Dean Moor Solar Farm

Environmental Statement: Chapter 7 – Figure 7.6 1-5 Landscape Strategy Plan on behalf of FVS Dean Moor Limited

26 August 2025
Prepared by: Stantec UK Ltd
PINS Ref: EN010155
Document Ref: D2.28
Deadline: 2
Revision: 2

Project Ref:	EN010155/6.2 ES Figure 7.6.1-7.6.5 Landscape Strategy Plan
Status	Final
Issue/ Rev:	2
Date:	August 2025

Rev: N/A

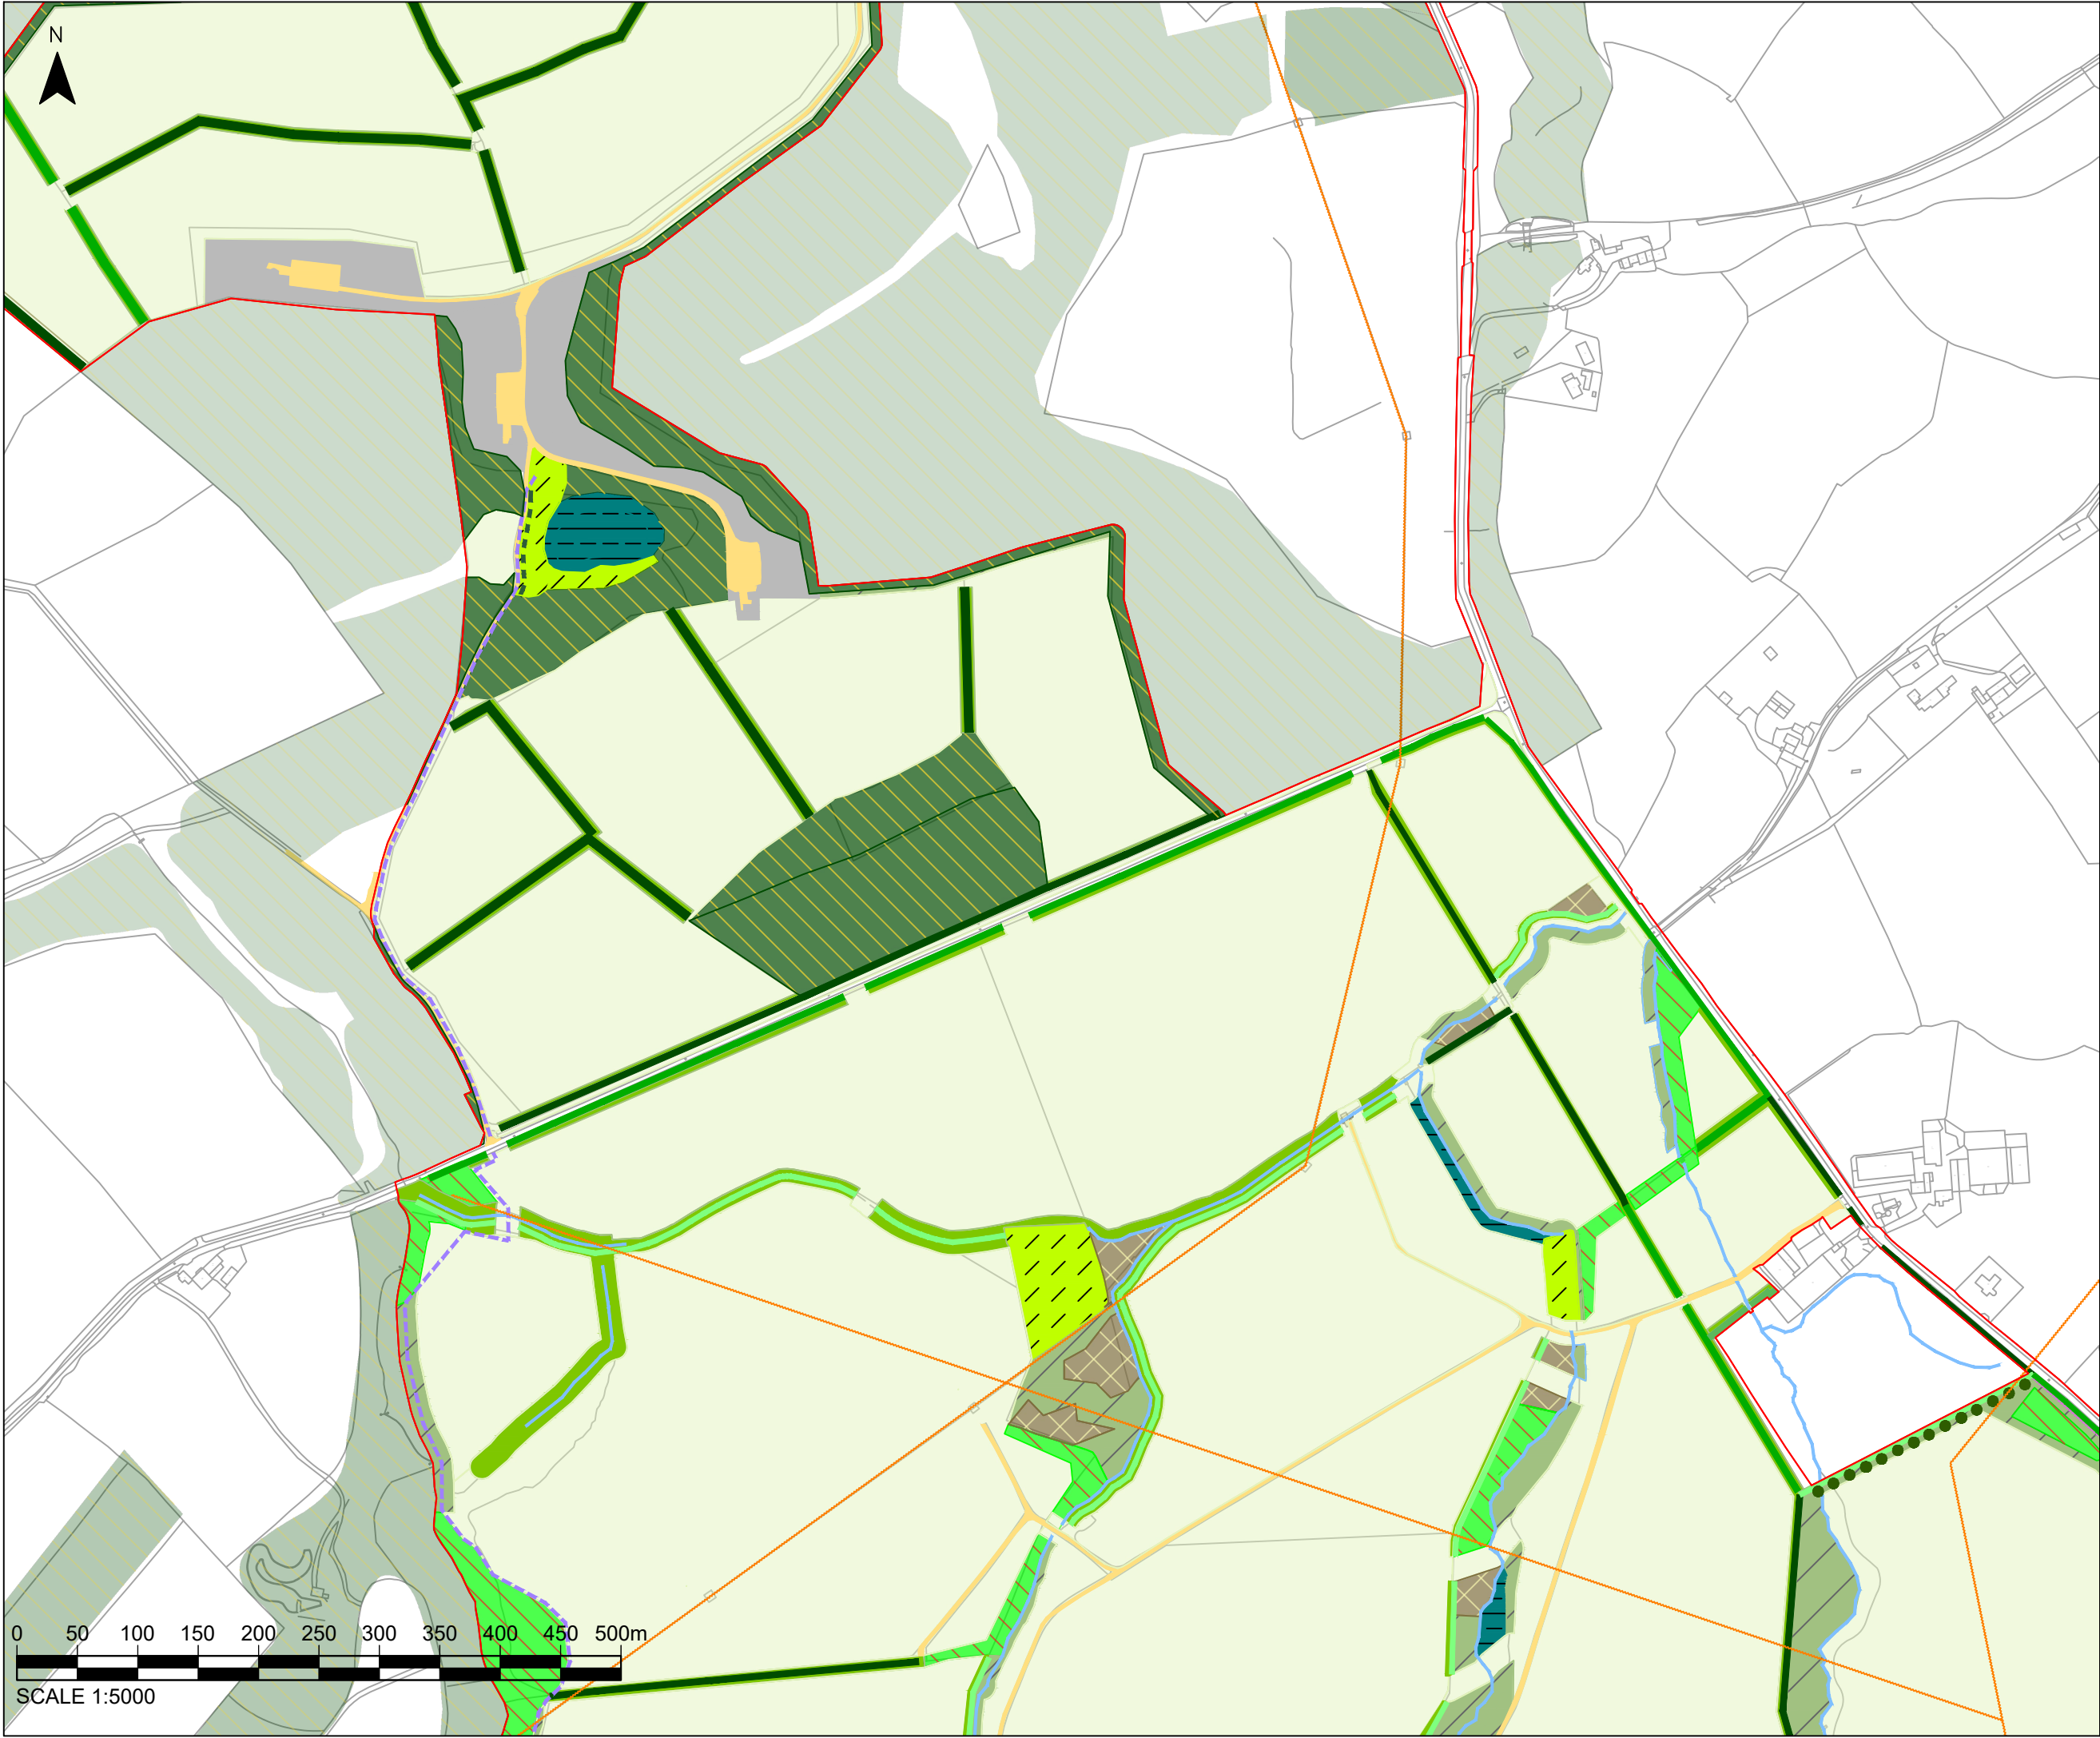
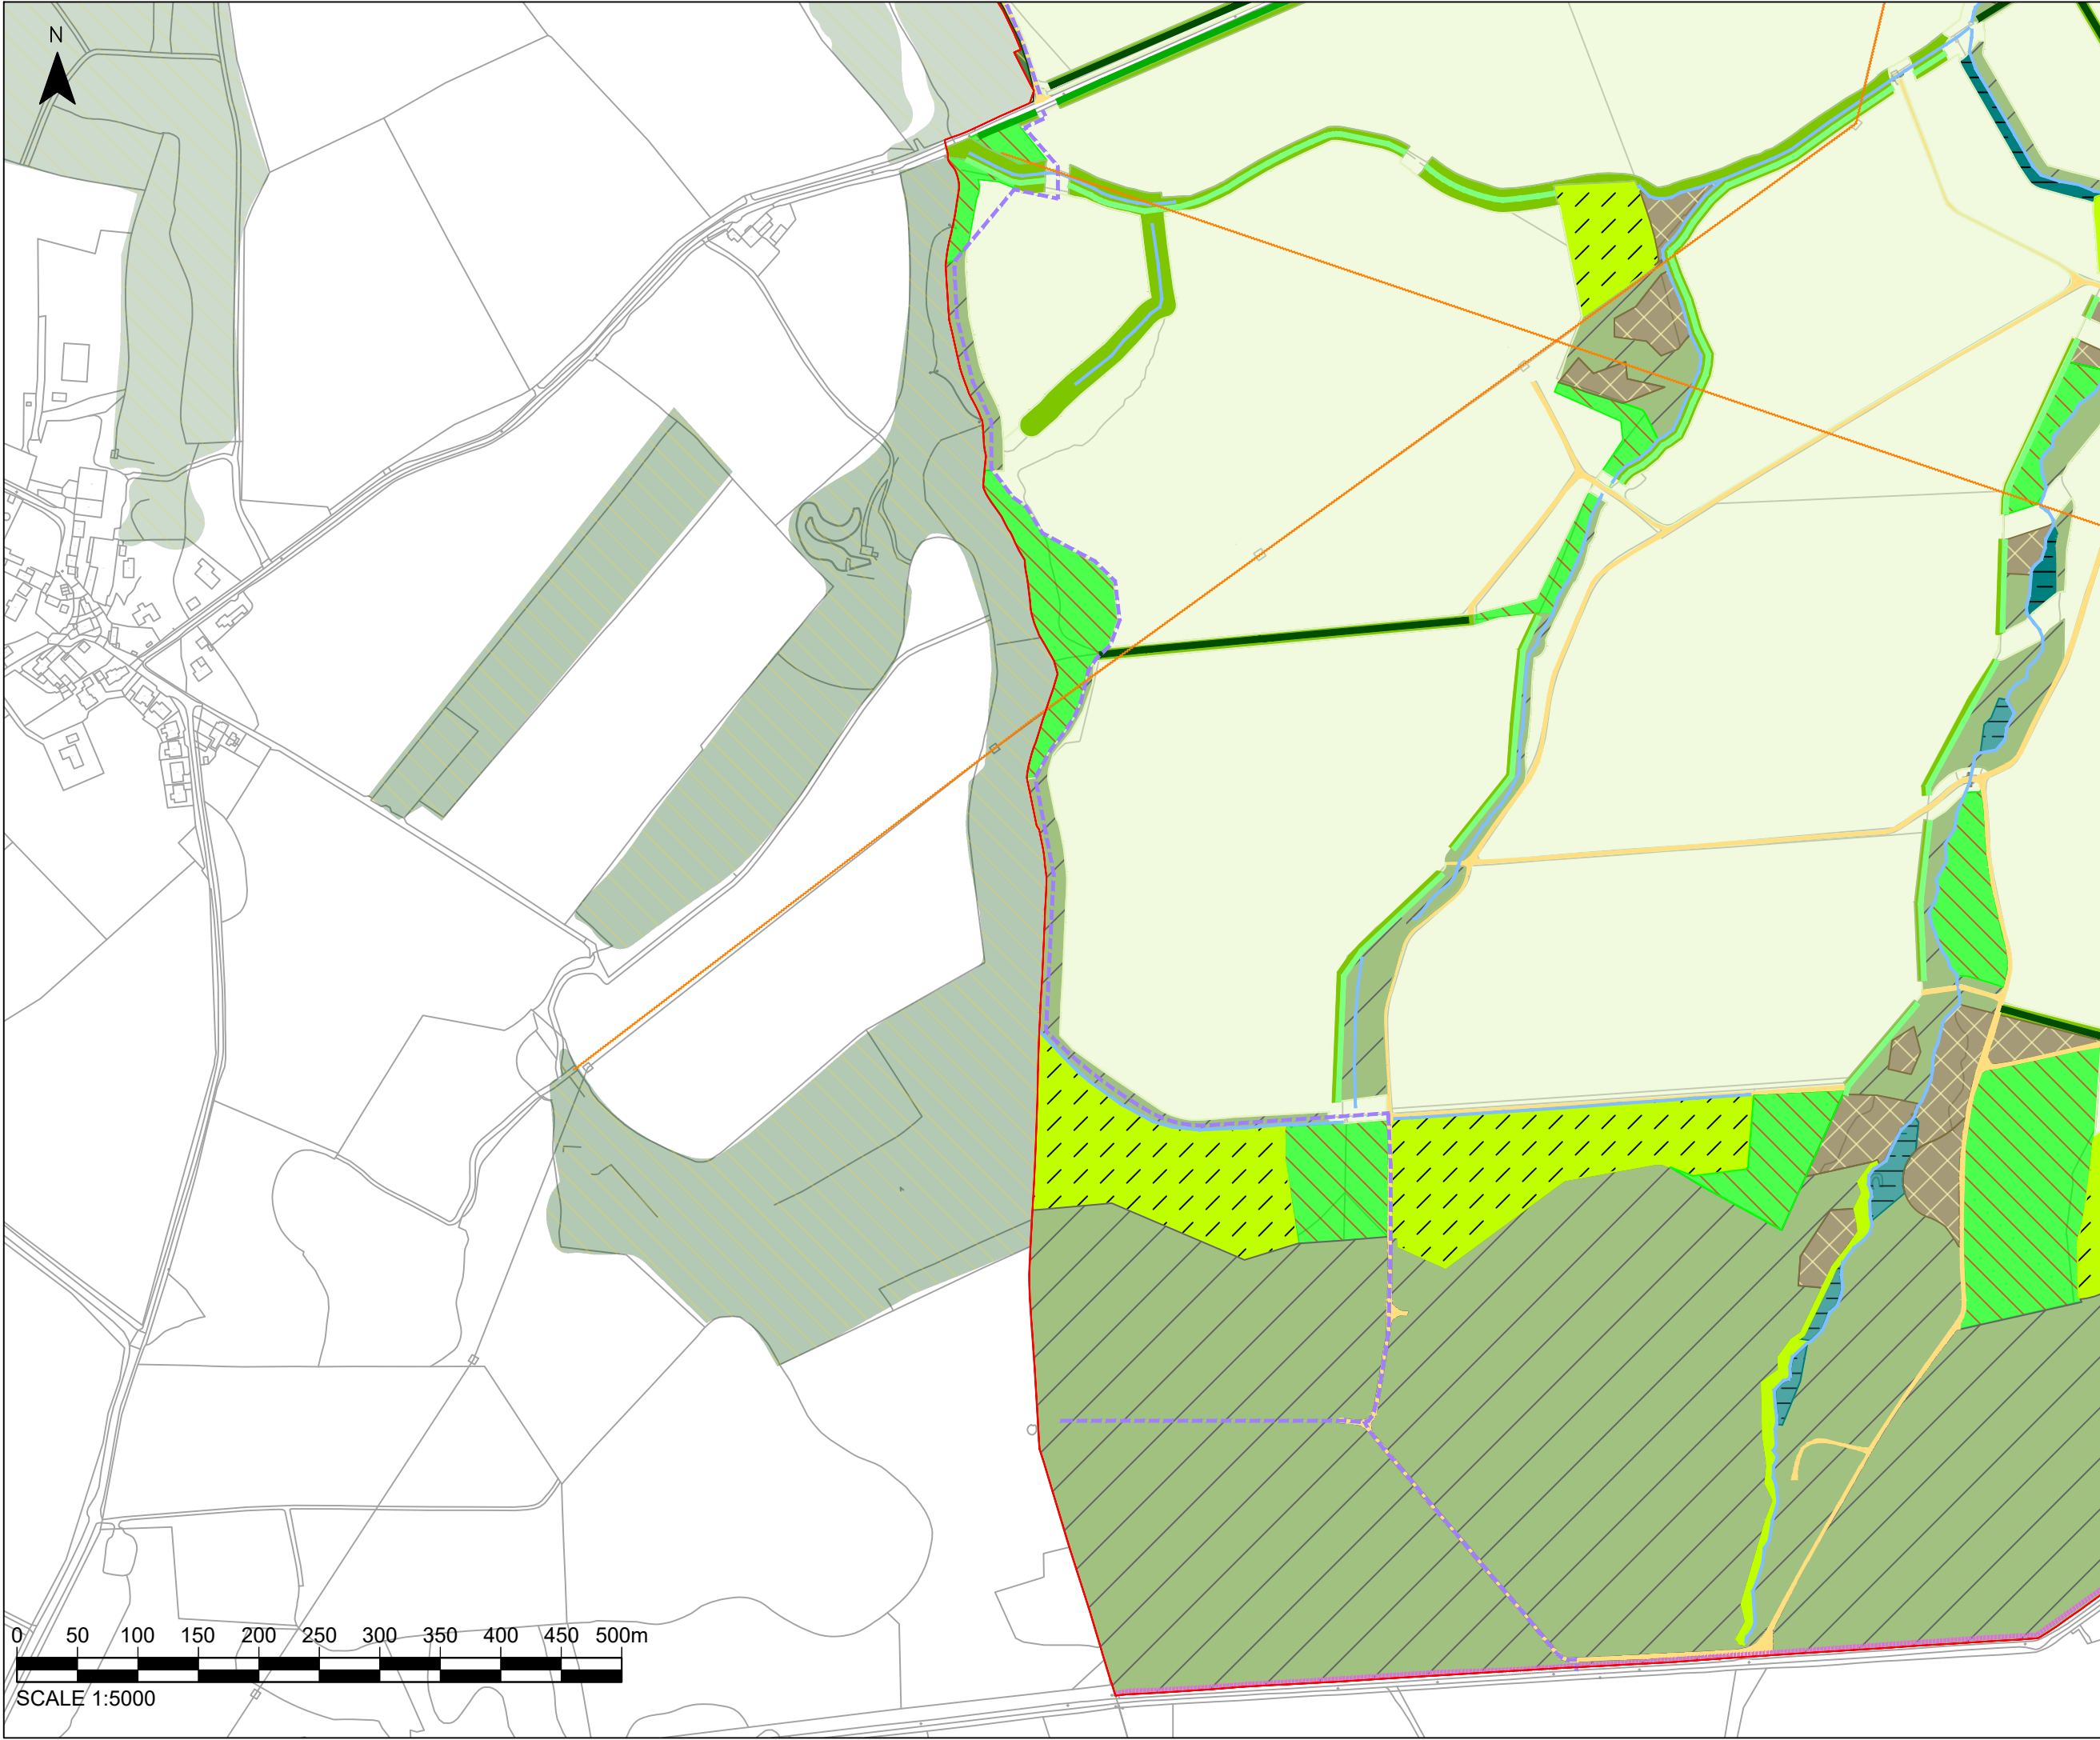
Revision	Reason
Dry stone wall line-style updated to darker purple and dashed	<p>Q6.0.2 of the Examining Authority's (ExA) first written questions stated:</p> <p><i>"The Landscape Strategy plan [APP-088] includes a number of colour coded features which are similar and difficult to discern (for example, existing and proposed hedgerows). Please amend."</i></p>
Willow screening hedge line-style changed to smaller dash and changed from green to reddish/brown	
Existing woodland (Coniferous) updated to crosshatch (easier to distinguish between coniferous/broadleaved)	
Acid grassland hatch changed to differentiate better between this and existing woodland	
Native planting to protect watercourse changed colour to darker blue	
Marginal planting hatch colour made slightly lighter blue to distinguish between this and native planting to protect watercourse	
All hedge line-styles/colours changed to make it easier to distinguish between them

Other grassland colour made lighter	
Broadleaf woodland hatch changed to distinguish better between grassland and woodland colours
